Application for a non-material amendment following a grant of planning permission.

Removal of orangery structure and replace with extension, associated alterations and access improvement.

Reference number:	<input type="text" value="S.20/0737/HHOLD"/>
Date of decision	<input type="text" value="16/06/2020"/>

Minor non material amendment to amend construction details to external envelope to remove flat ridge fixed rooflight over living room extension & simplification of stone parapet gable ends to North & South elevations.

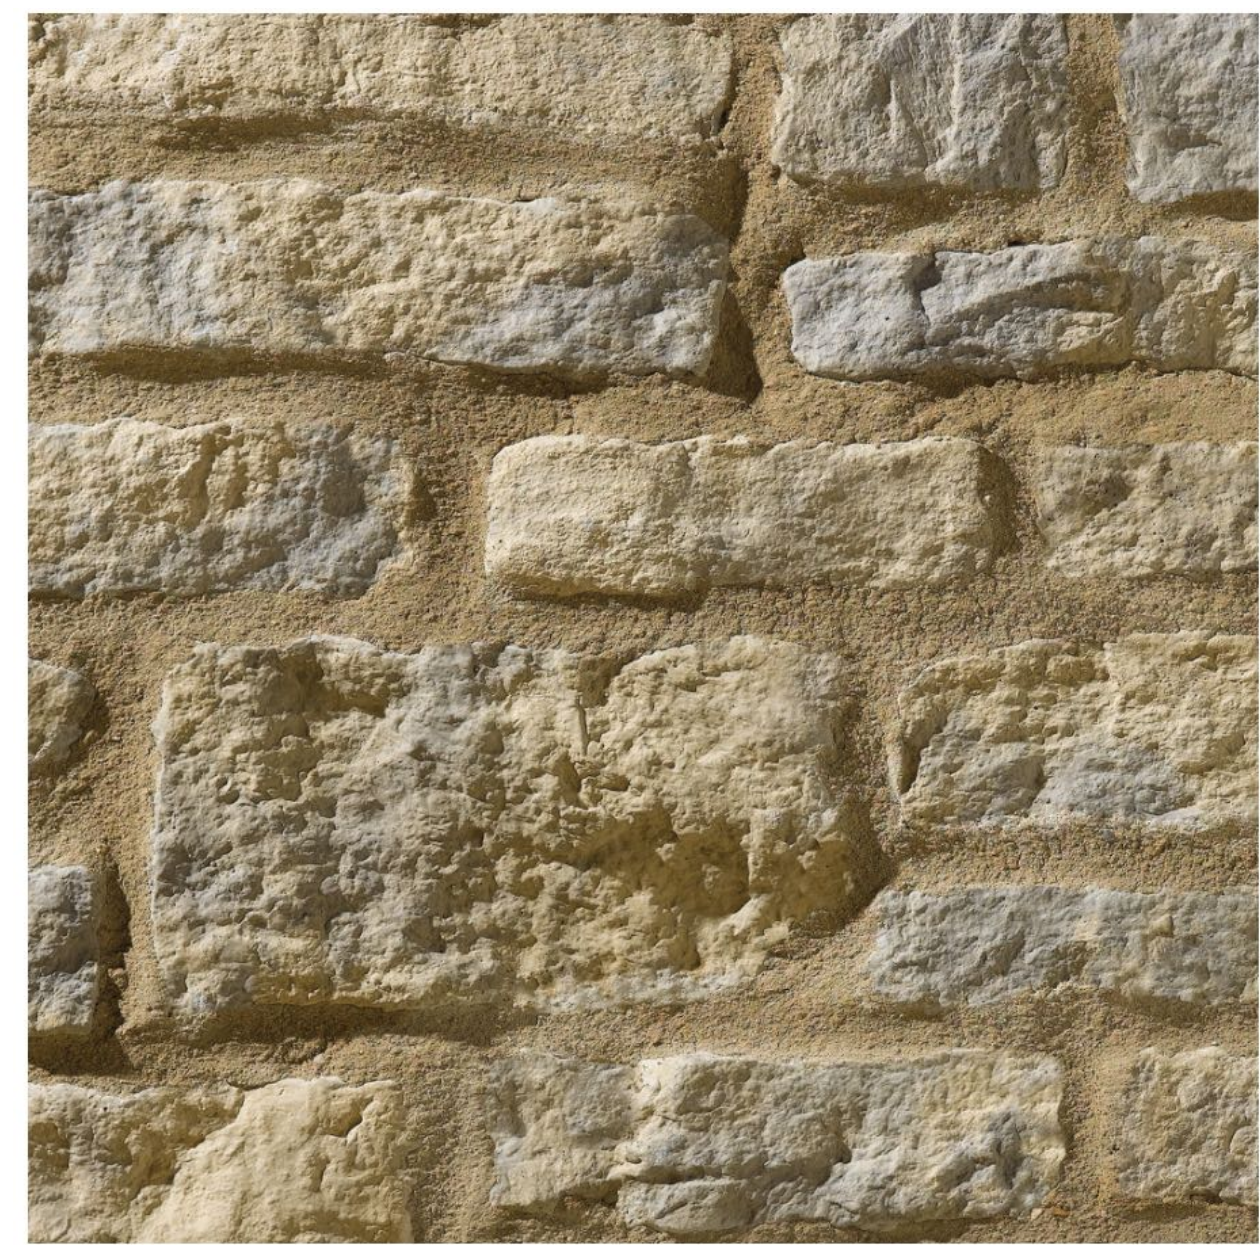
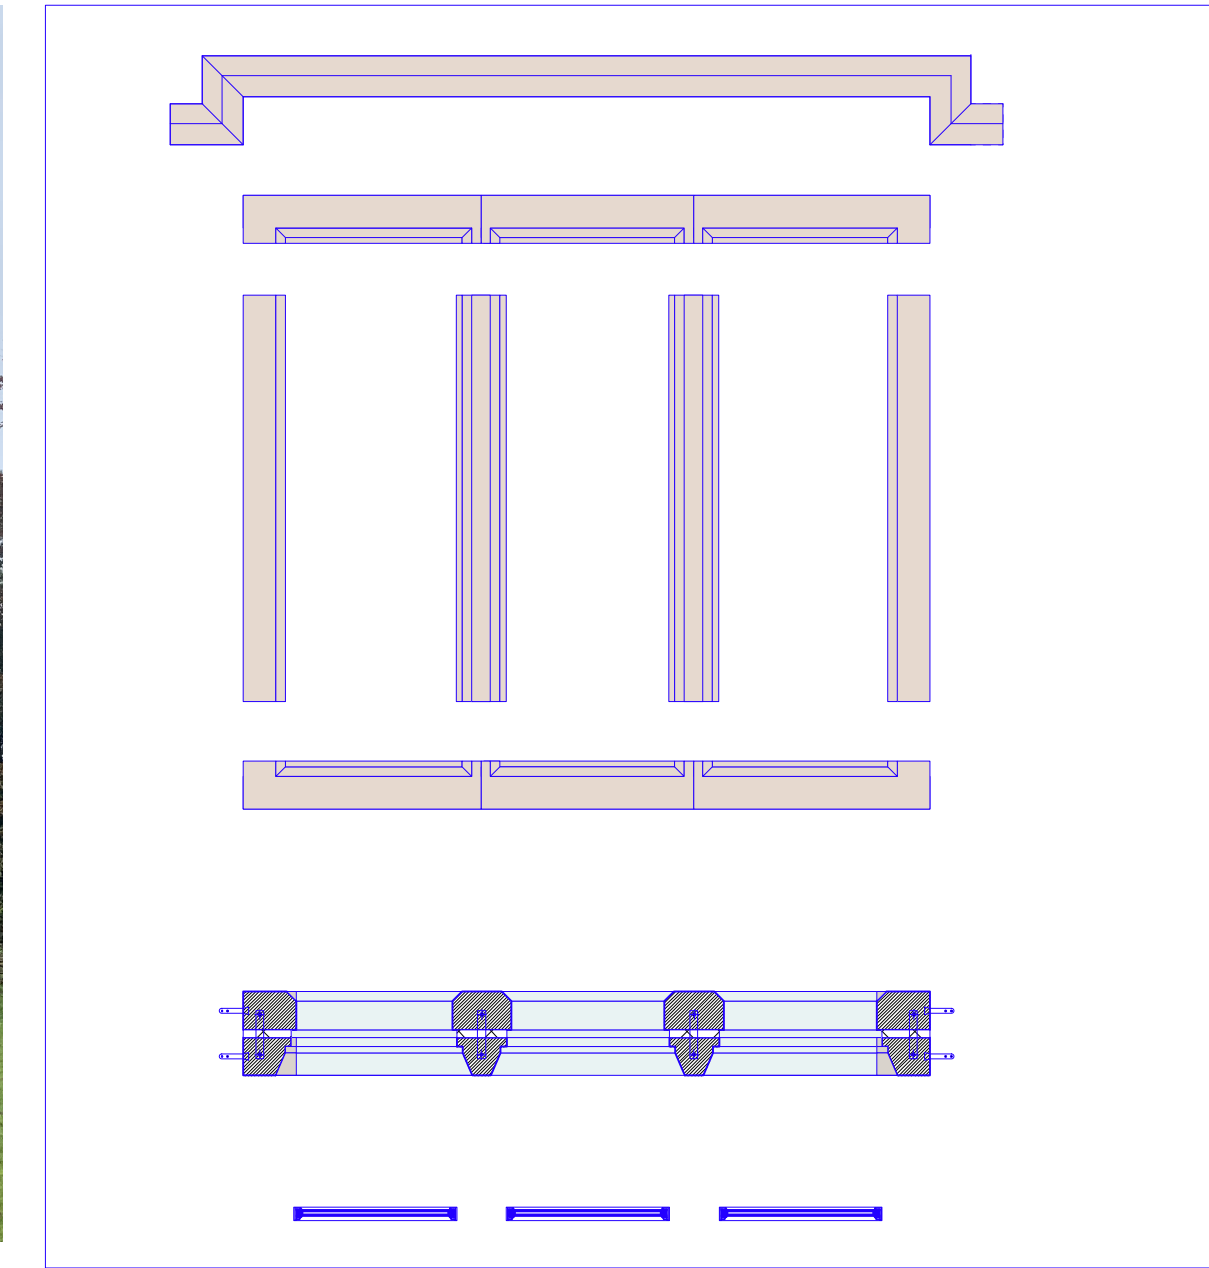
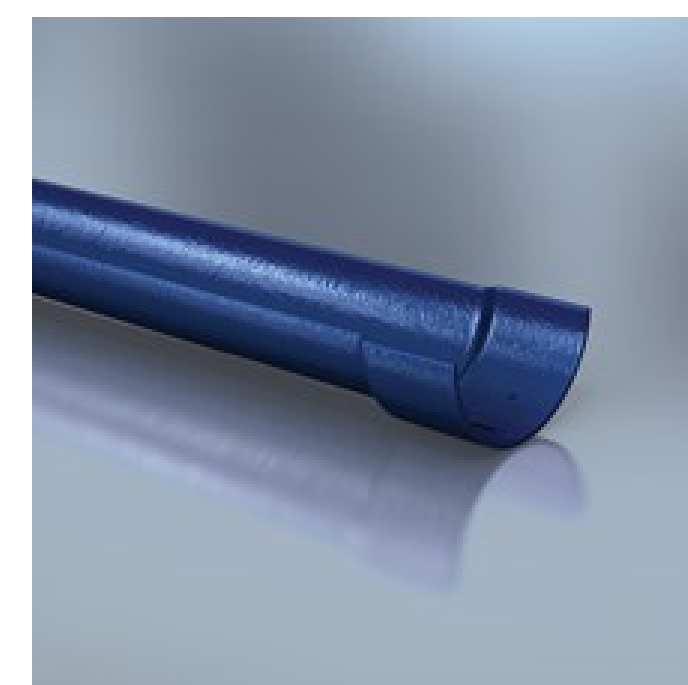
Client led decision to make the approved scheme more traditional in aesthetic, remaining in keeping with the existing form of the original dwelling. The same overall function and layout is retained as part of the proposal. Likewise, external materiality remains as previously approved, see submitted material details for more information.
